DRB Application No.: 04DRB-01130 (P&F)	Project # 1003567
Project Name: MCDONALD ACRES UNIT 3	
Agent: Rhombus PA	Phone No.: 881-6690
<del></del>	(FINAL PLATS), MASTER DEVELOP. PLAN), was delegation of signature(s) to the following departments. O BE ADDRESSED
TRANSPORTATION:	
UTILITIES: Weed water and  of services from  Weel New Custome	sever tops for lot 30-B (separation by 30-A)  r sensce account opened for new sives
CITY ENGINEER / AMAFCA:	
D PARKS / CIP:	
□ PLANNING (Last to sign):	
-Tax printout from the County A Include 3 copies of the approv County Treasurer's signature with the County Clerk.	ropy for the County Clerk.  Treasurer.  to the County Clerk). RECORDED DATE:  Assessor.  The state plan along with the originals.  The state plan along with the recording of the plat.  The state plan along with the recording of the plat.  The state plan along with the originals.  The state plan along with the originals.

## Development Review Board Comments

RE: McDonald Acres, Unit 3/minor plat

THE PURPOSE OF THIS PLAT IS TO CREATE THREE LOTS OUT OF TWO LOTS.

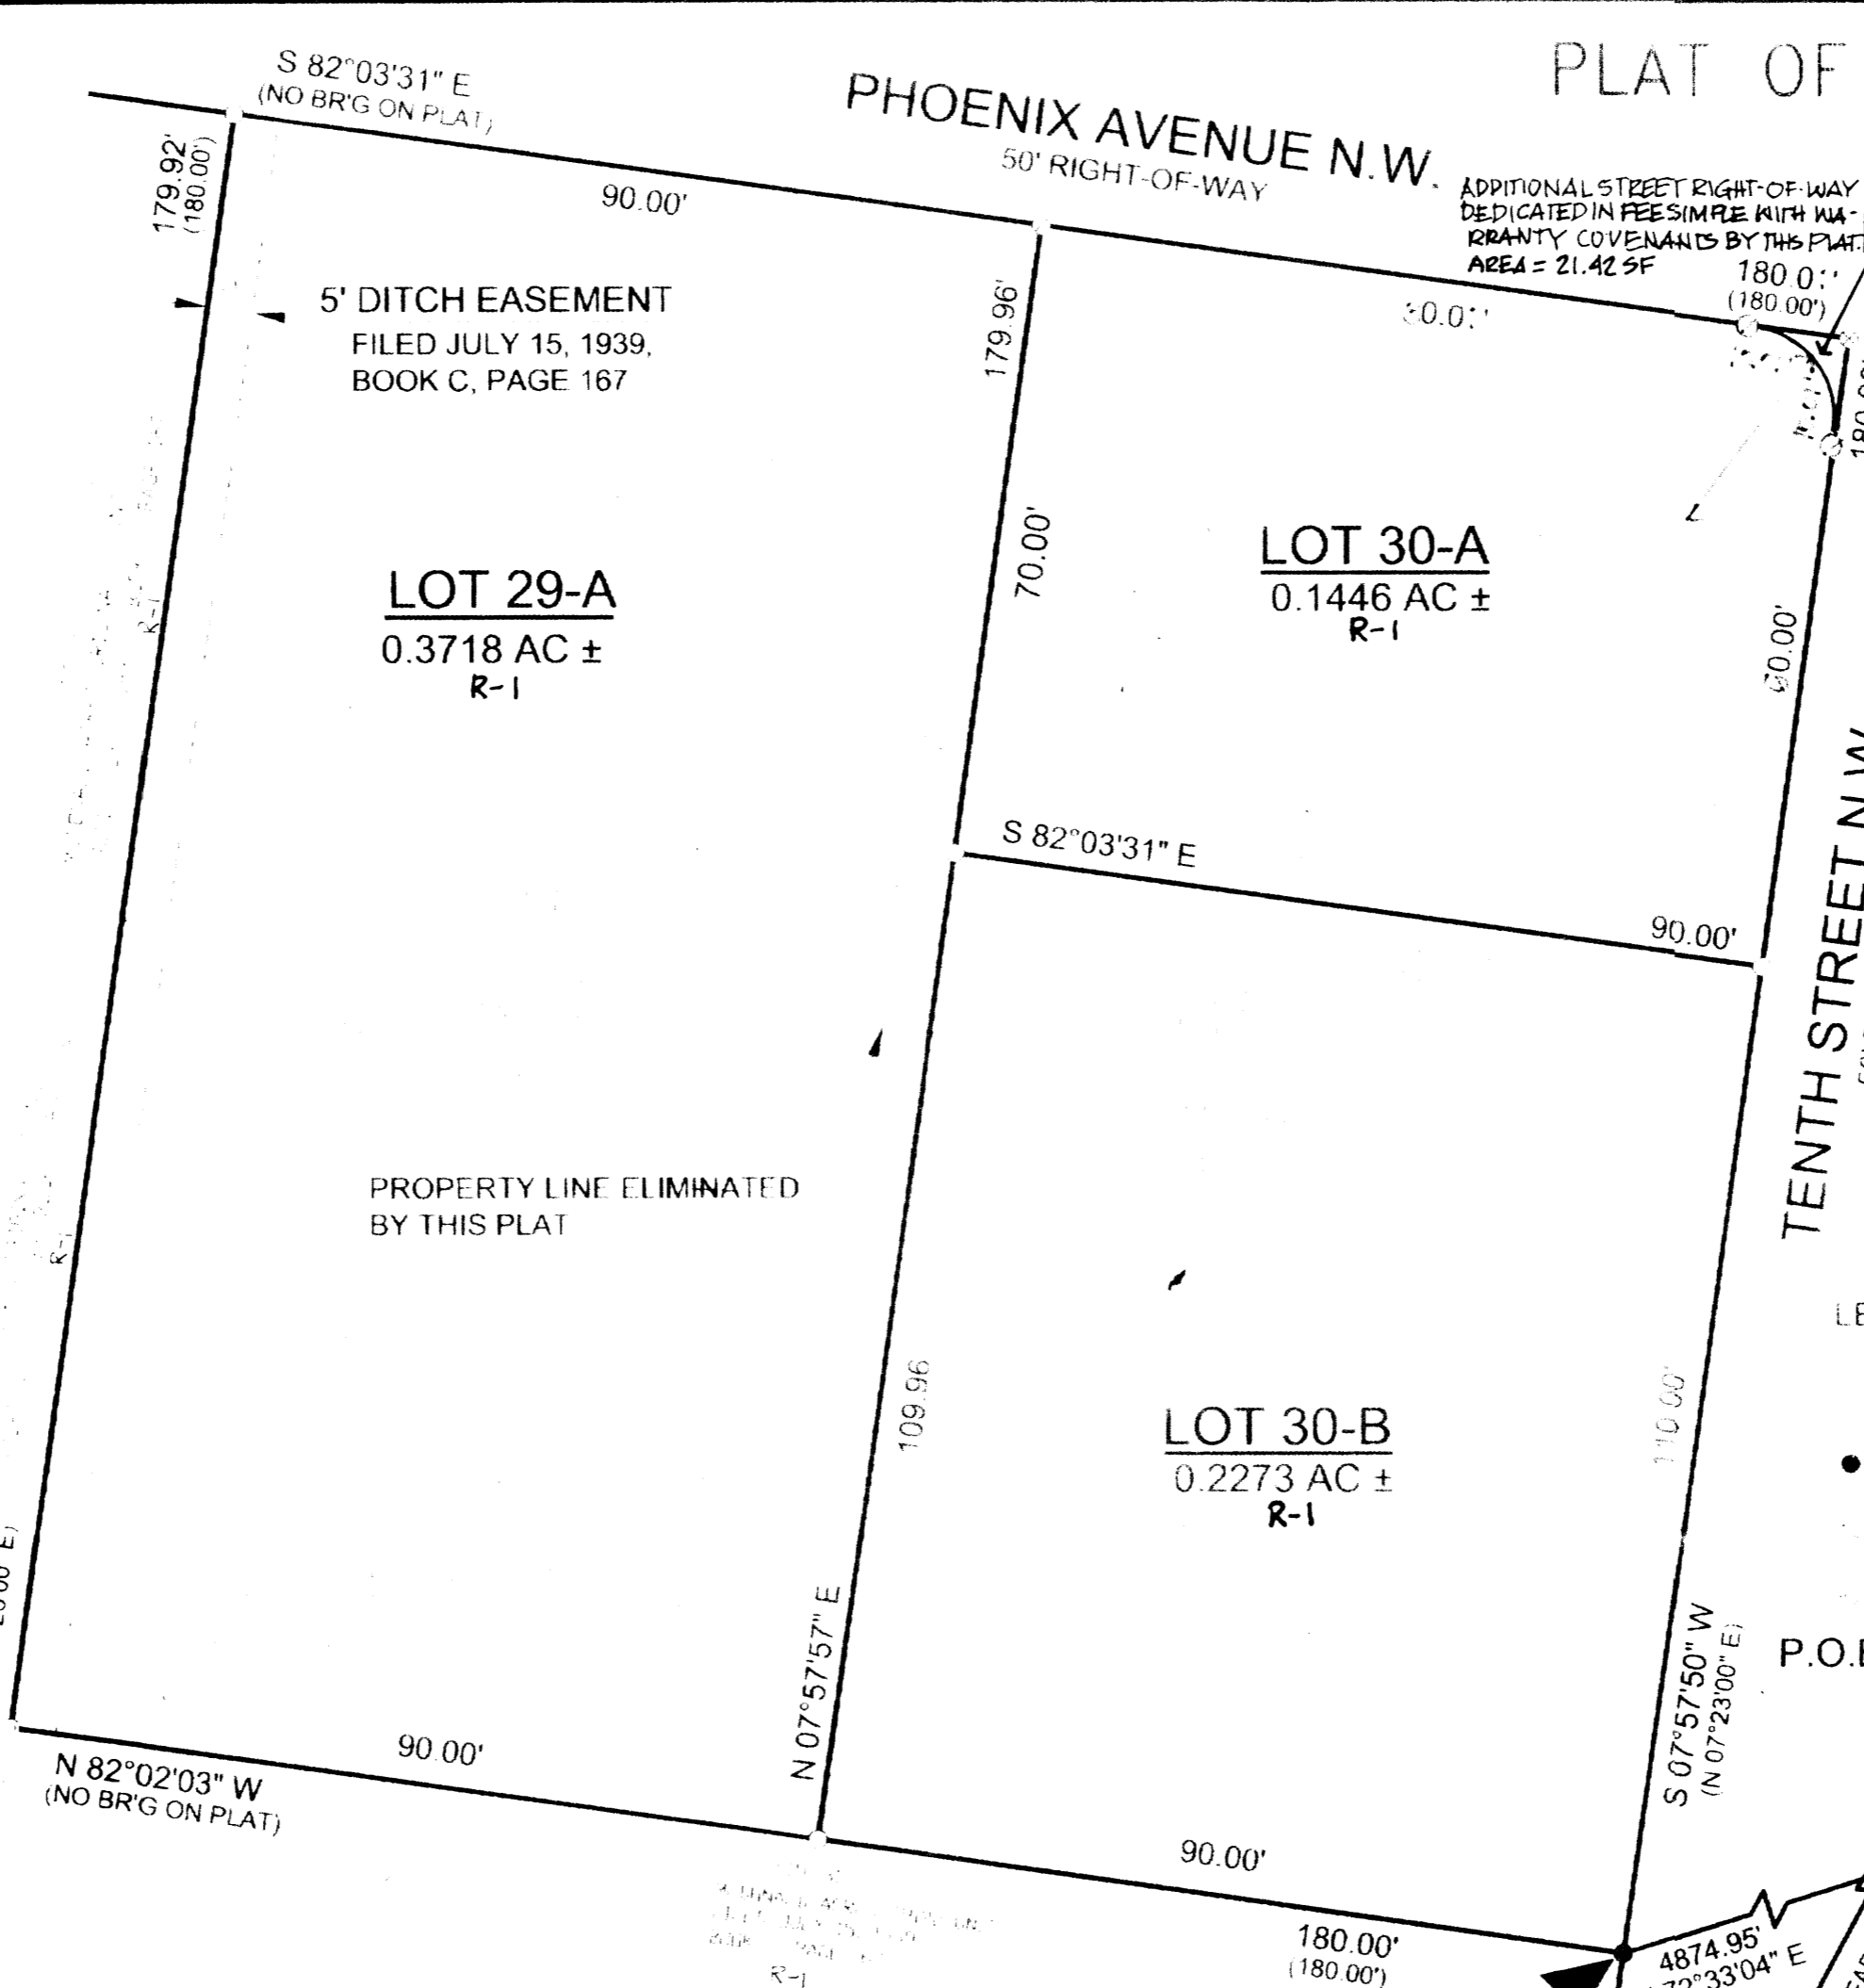
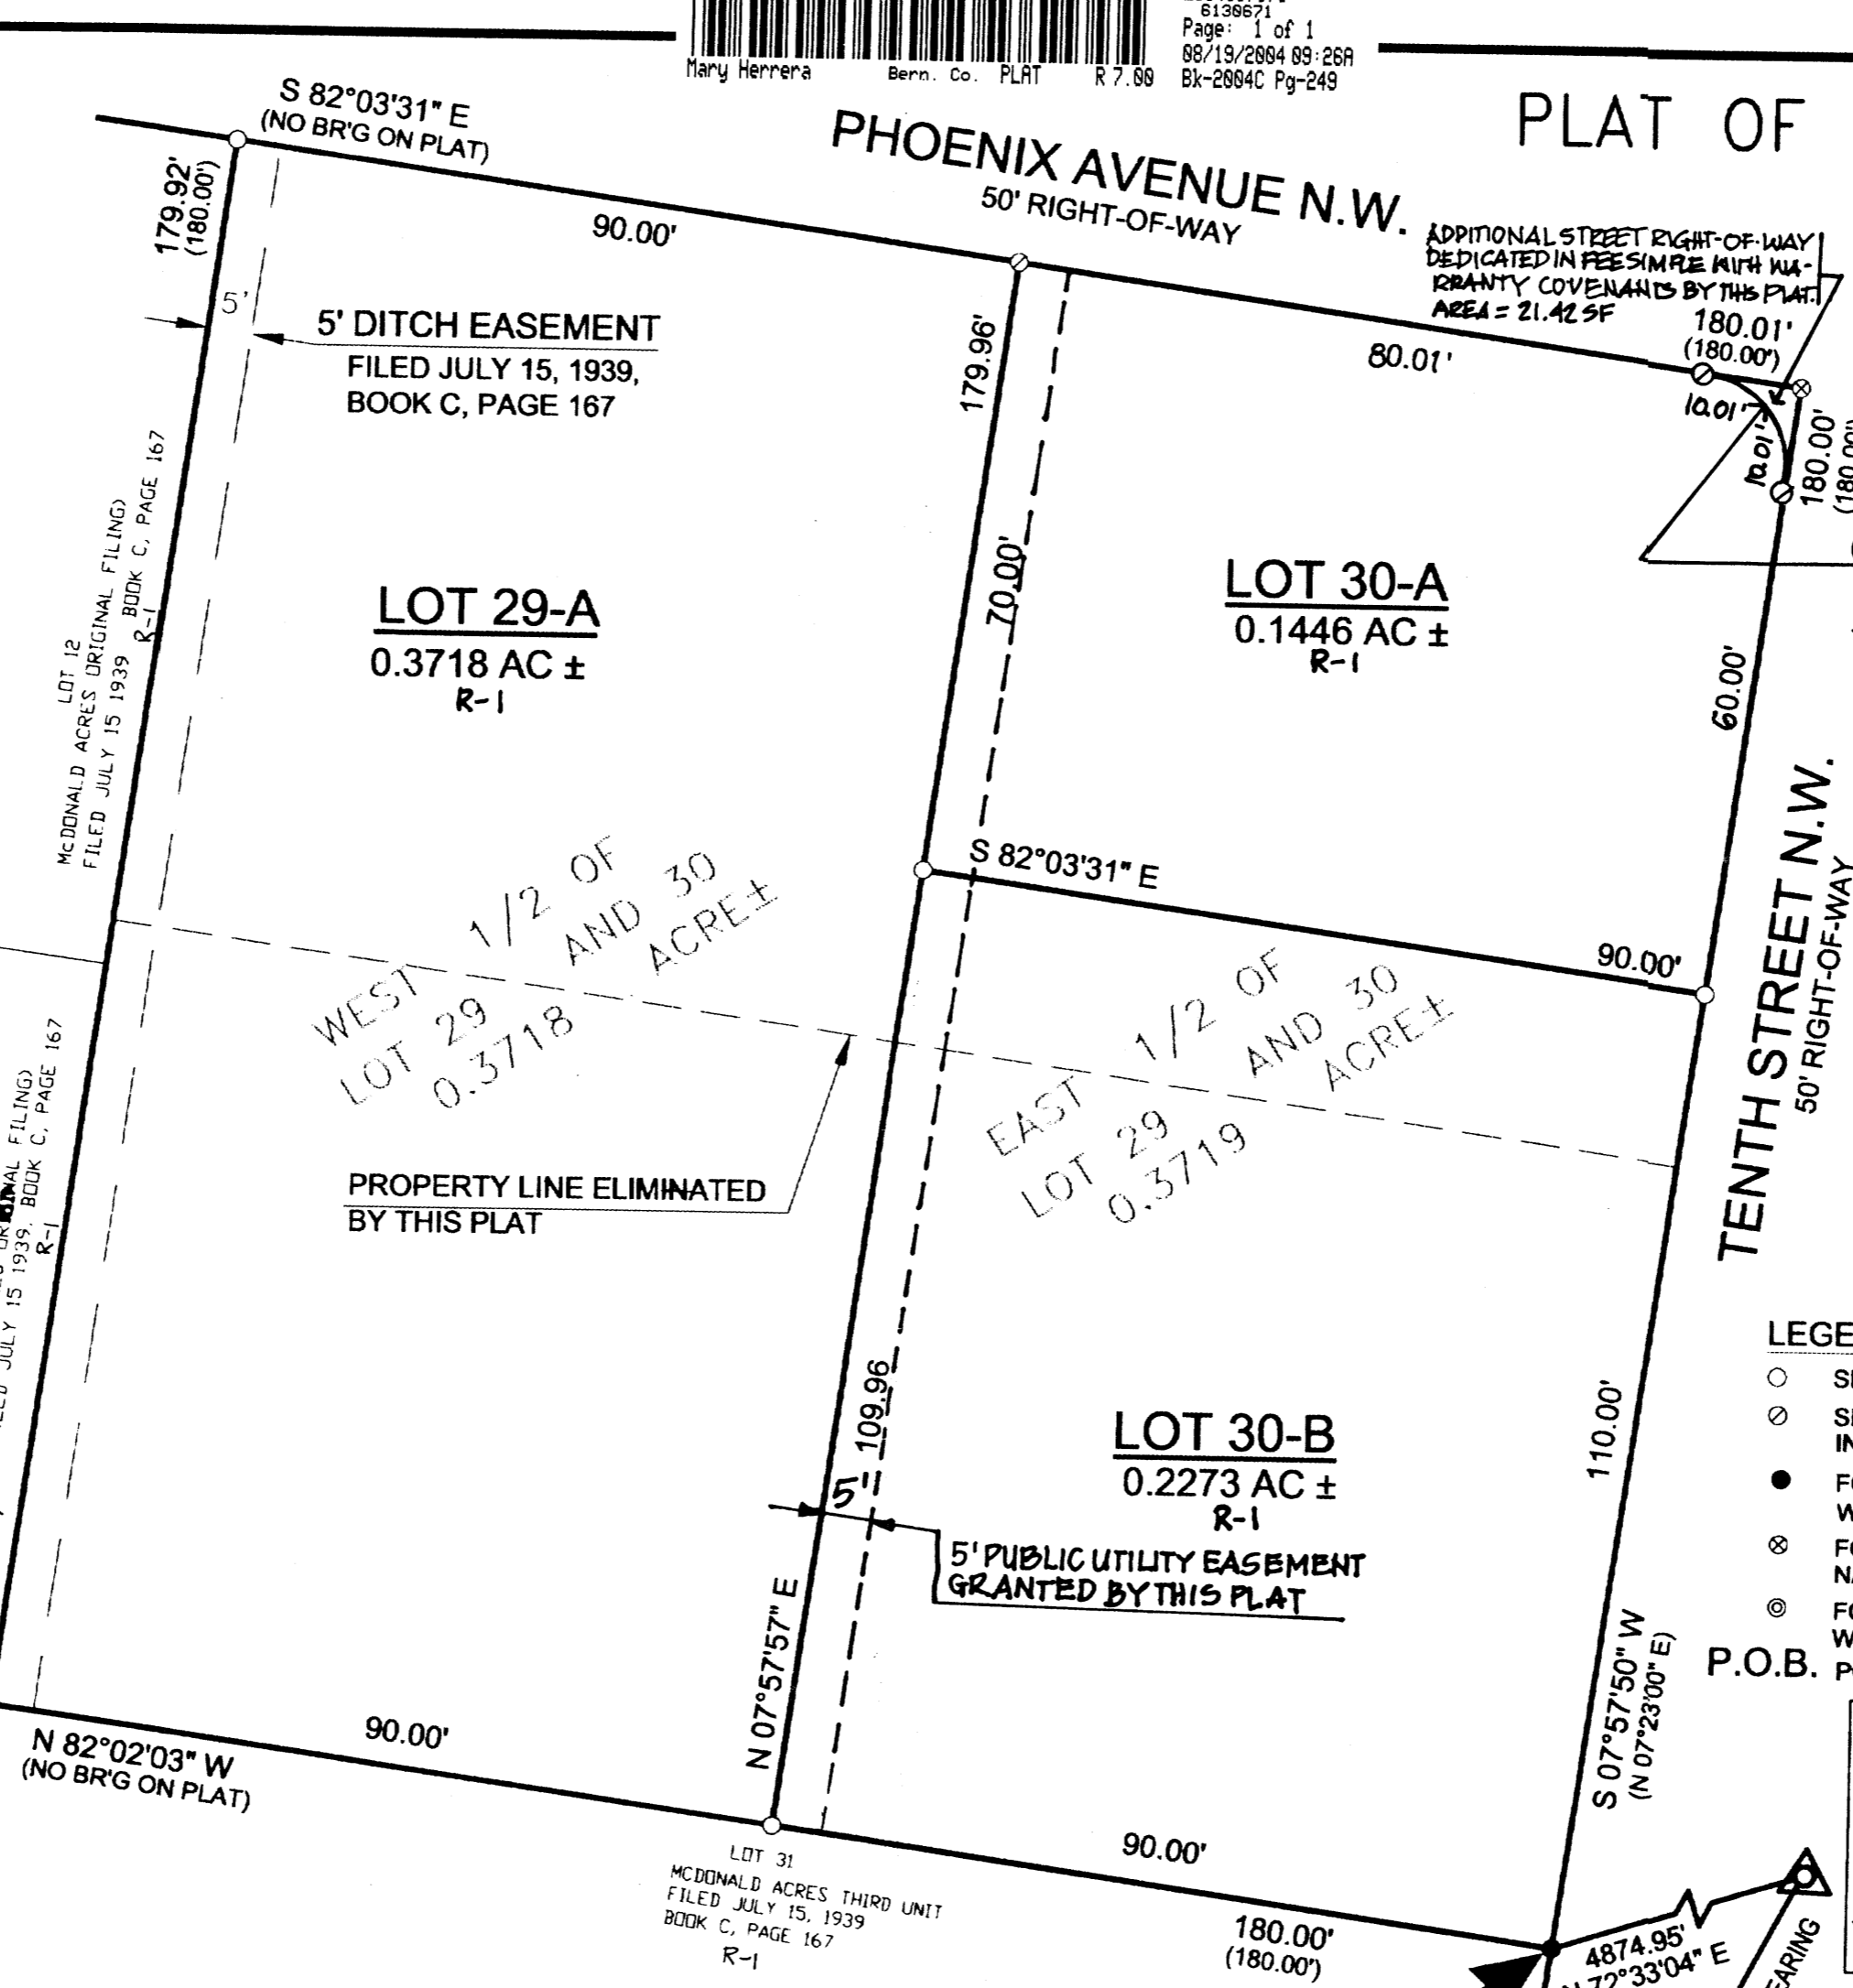
- 1) What is width of sidewalk along 10th and Phoenix?
- 2) Radius dedication is needed at corner of 10<sup>th</sup> and Phoenix. (20')
- 3) Will any curb cuts be modified? Any new curb cuts required?

To make the property less noncomforming to Zone Code requirements, this replat is an improvement. However, the proposed lot line running north/south between the 2 single family homes should be moved another 3.6 feet to the east, closer to the residence in the northeast corner. This will allow the residence in the northwest corner to have a 6.2 foot side yard setback and make it more conforming than proposed by the replat. Due to the width of the lots on the north side of the property, the side yard setback is actually 10 feet for each lot.

Once this lot line is moved, Planning has no objection to approving the plat.
